**ADC Planning Consultation
Conservation/Design Officer Response**

Application Number	AW/82/18/HH
Address	232 Manor Way Aldwick PO21 4HT
Description	Proposed cladding to upper side & rear elevations. This application affects the character and appearance of Aldwick Bay Conservation Area
Case Officer	Andrew Wood
Date	11 th April 2018

PROPOSED FITTING OF WHITE DURASID CLADDING TO THE UPPER
SIDE AND REAR ELEVATIONS OF 232 MANOR WAY ALDWICK

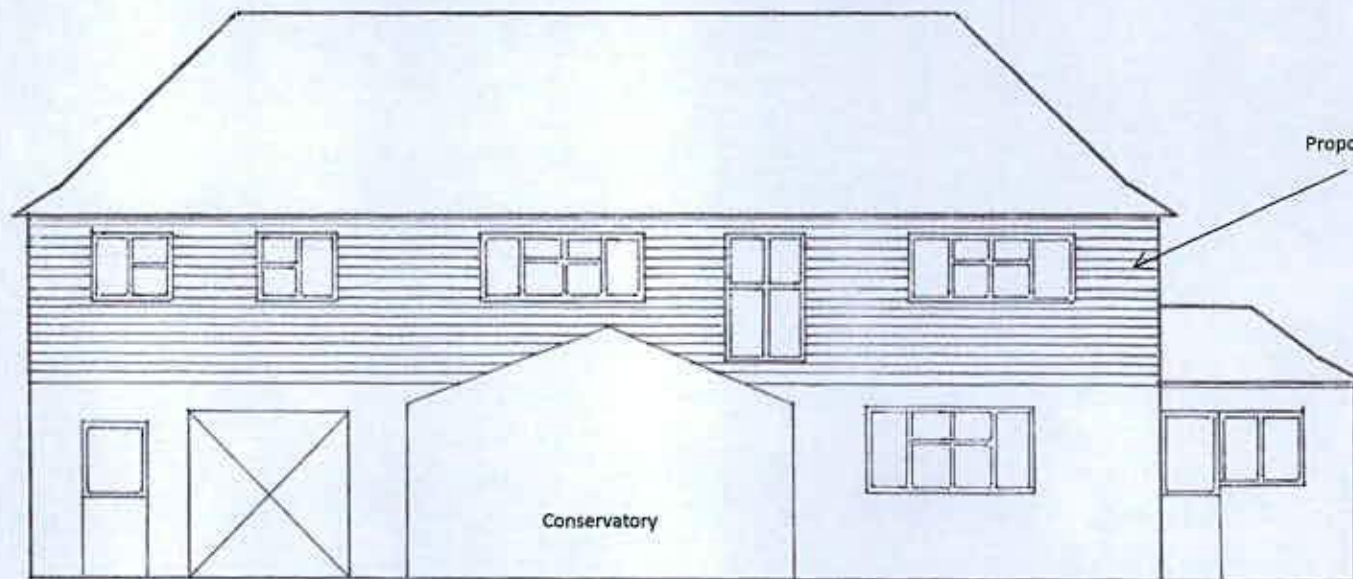
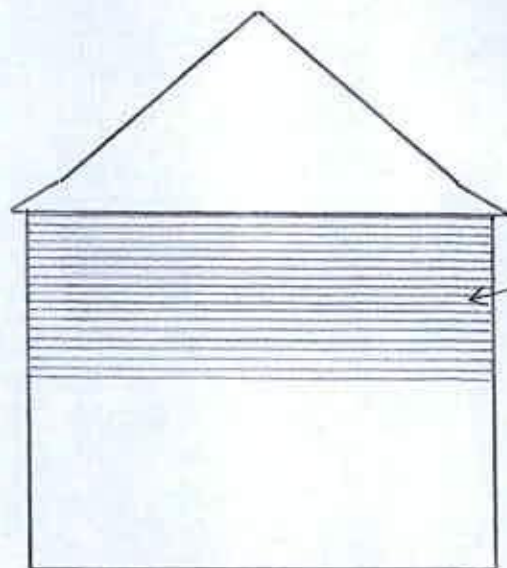
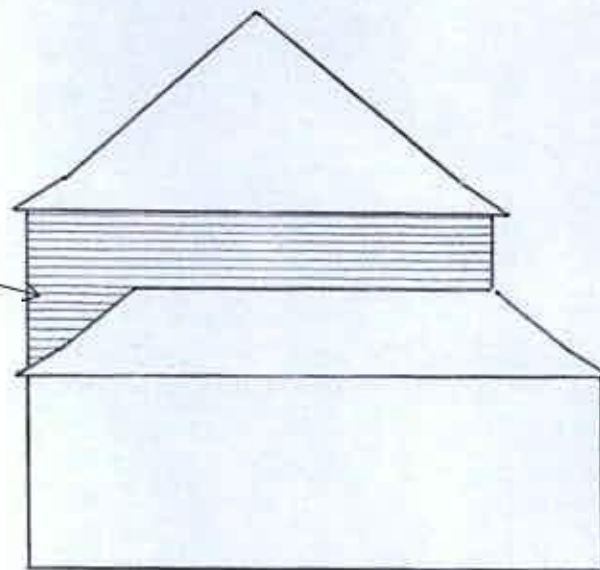
The proposal is to clad the building with a plastic cladding, namely 'Durasid'. It is noted that the applicant made a retrospective application to regularize similar cladding to the front of the property under AW/321/14/HH (Approved). The walls are currently roughcast painted render. The adjacent properties are roughcast render and brick & tile to elevation, under tile roof.

The Conservation Area is characterised by several architectural elements, including the style and spacing of properties, open space and material palette. It is considered that the proposed plastic cladding would represent an alien presence in terms of plasticised finish, and either smooth or wood-grain effect (not seen in traditionally finished timber boards).

It is therefore considered that the proposed would be detrimental to the character of the Conservation Area, and recommend that this application be refused on these and the following grounds:

- It is considered that the proposal fails to respect or enhance local distinctiveness

- It is considered that the proposal fails to enhance the character of the Conservation Area or its setting, and is detrimental to same.

- It is considered that the proposal fails to conserve or enhance the historic environment

- It is considered that the proposal does not adequately respond to local material or character
